# ENG-SF21020-R1-FDR.pdf Markup Summary

Add text:  
PCD Filing No.:  
SF-21-020

113

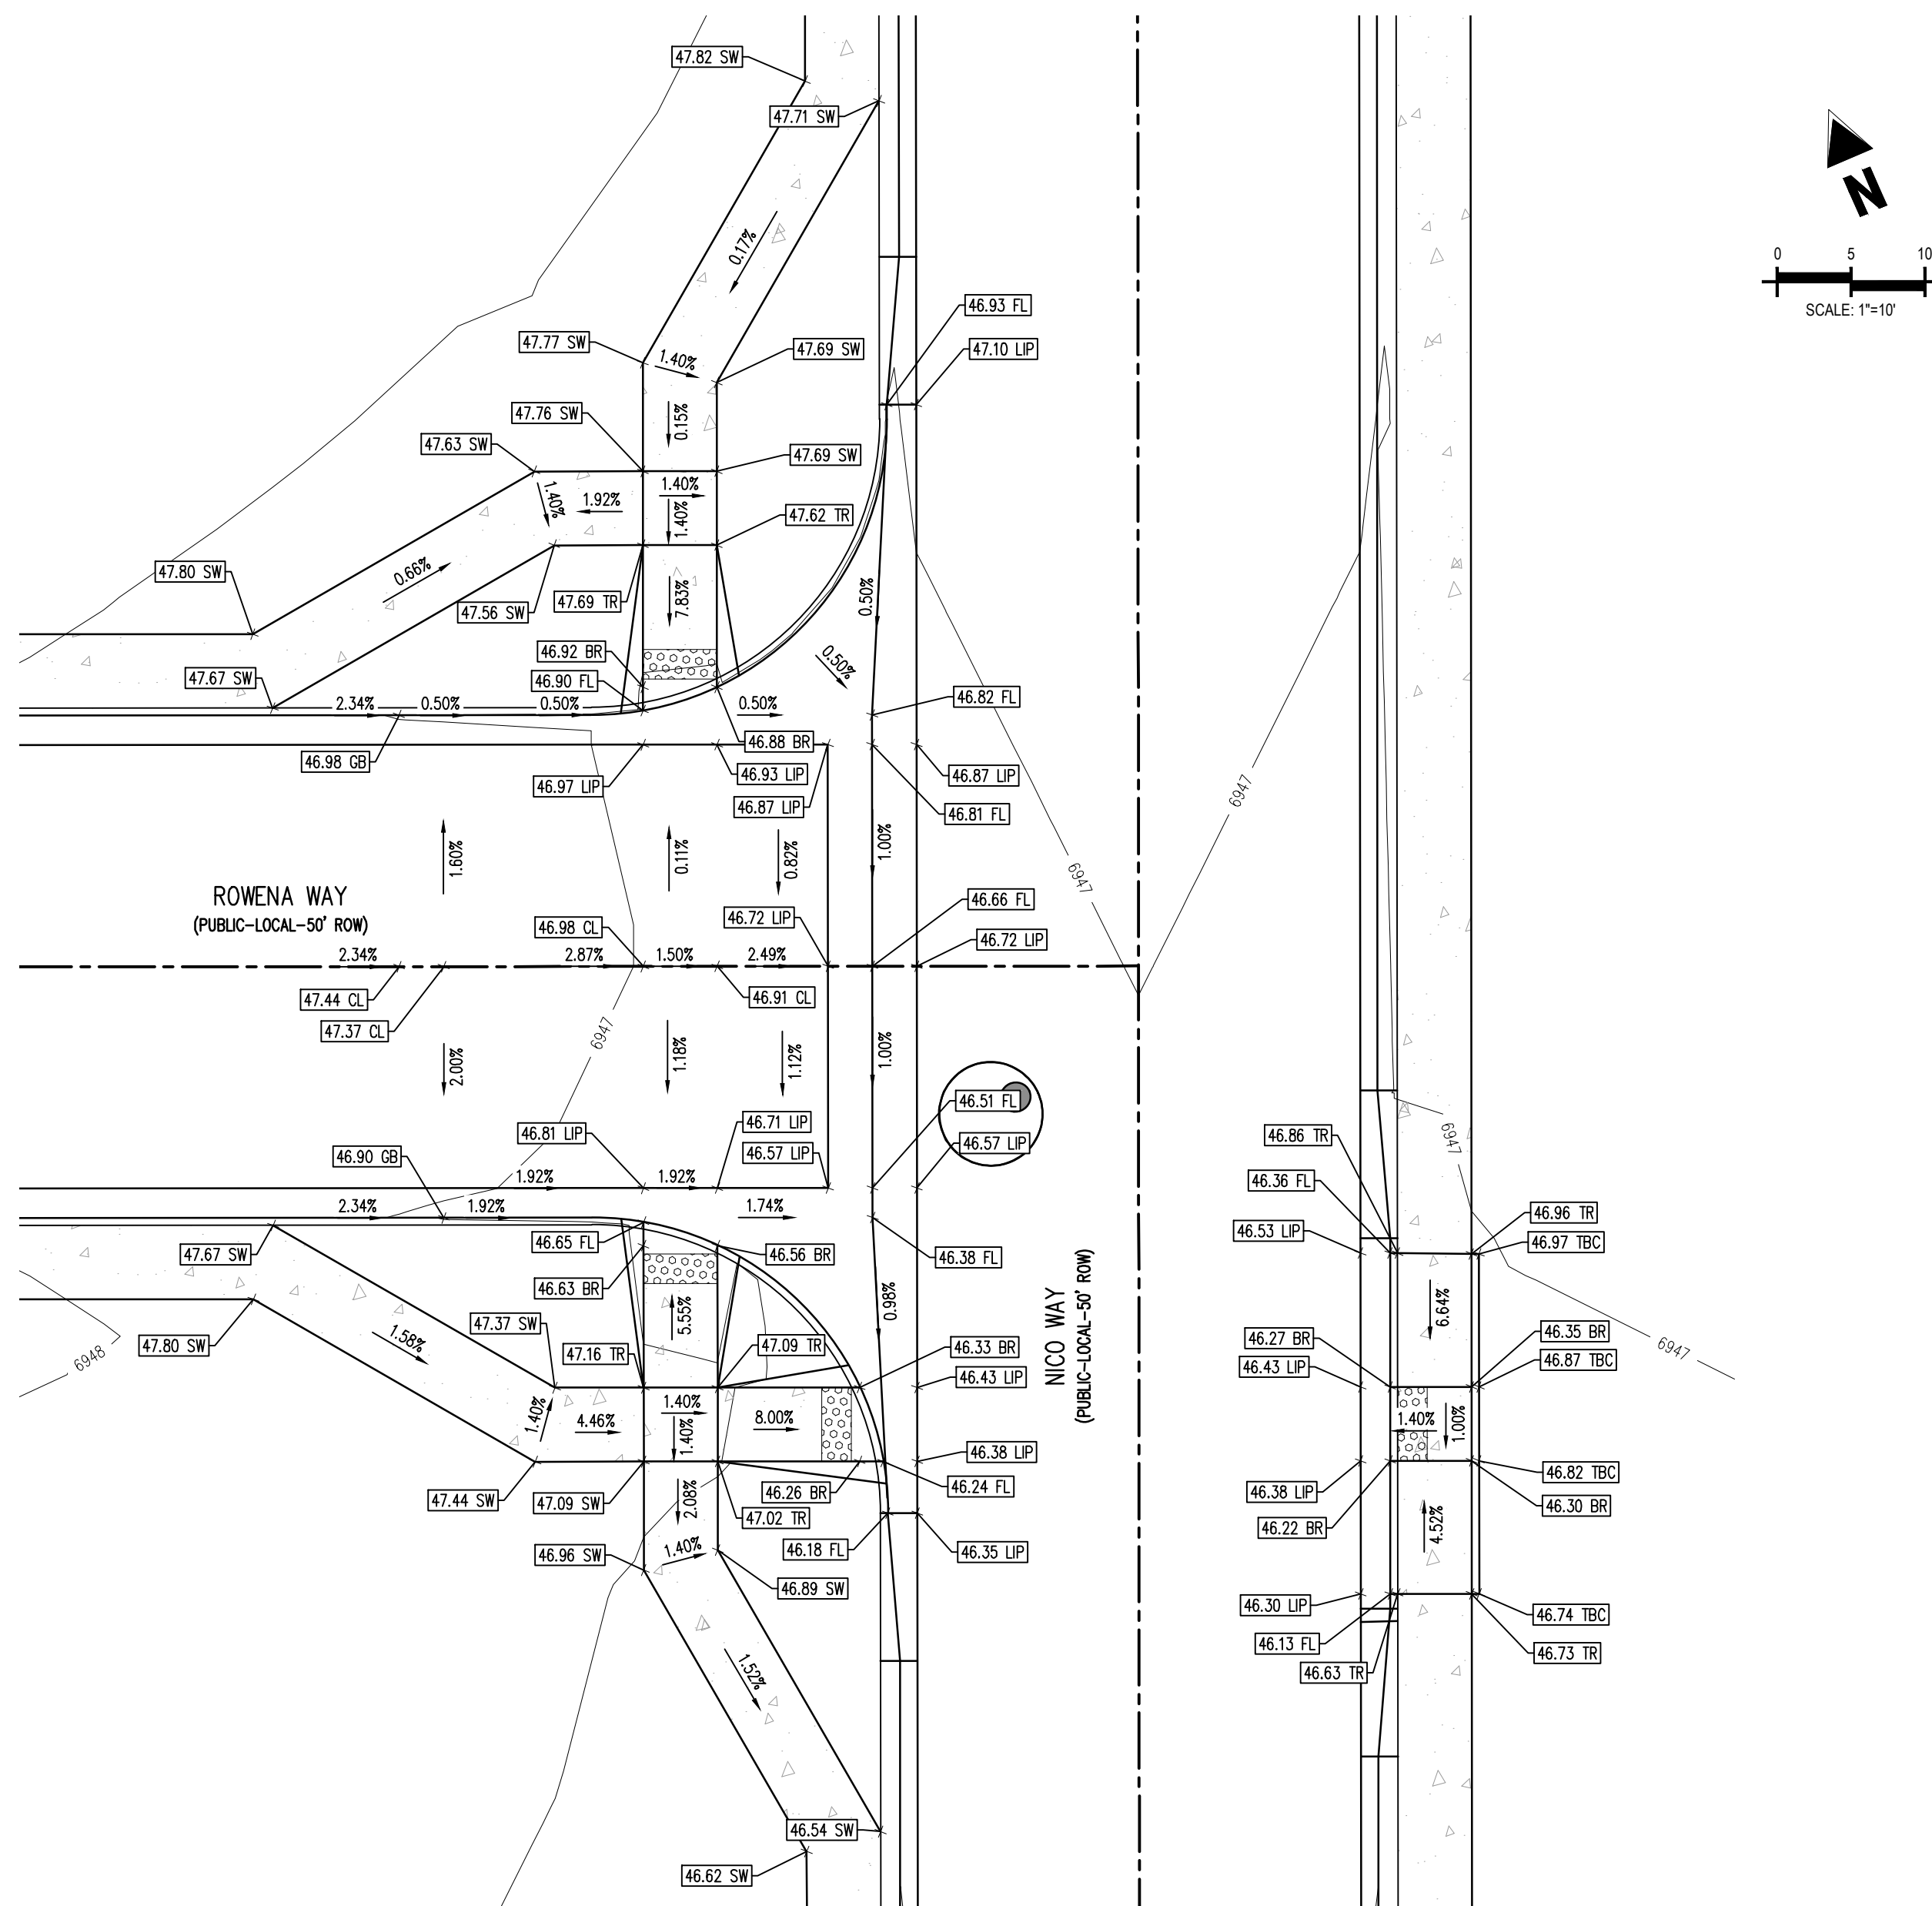
Show on CDs
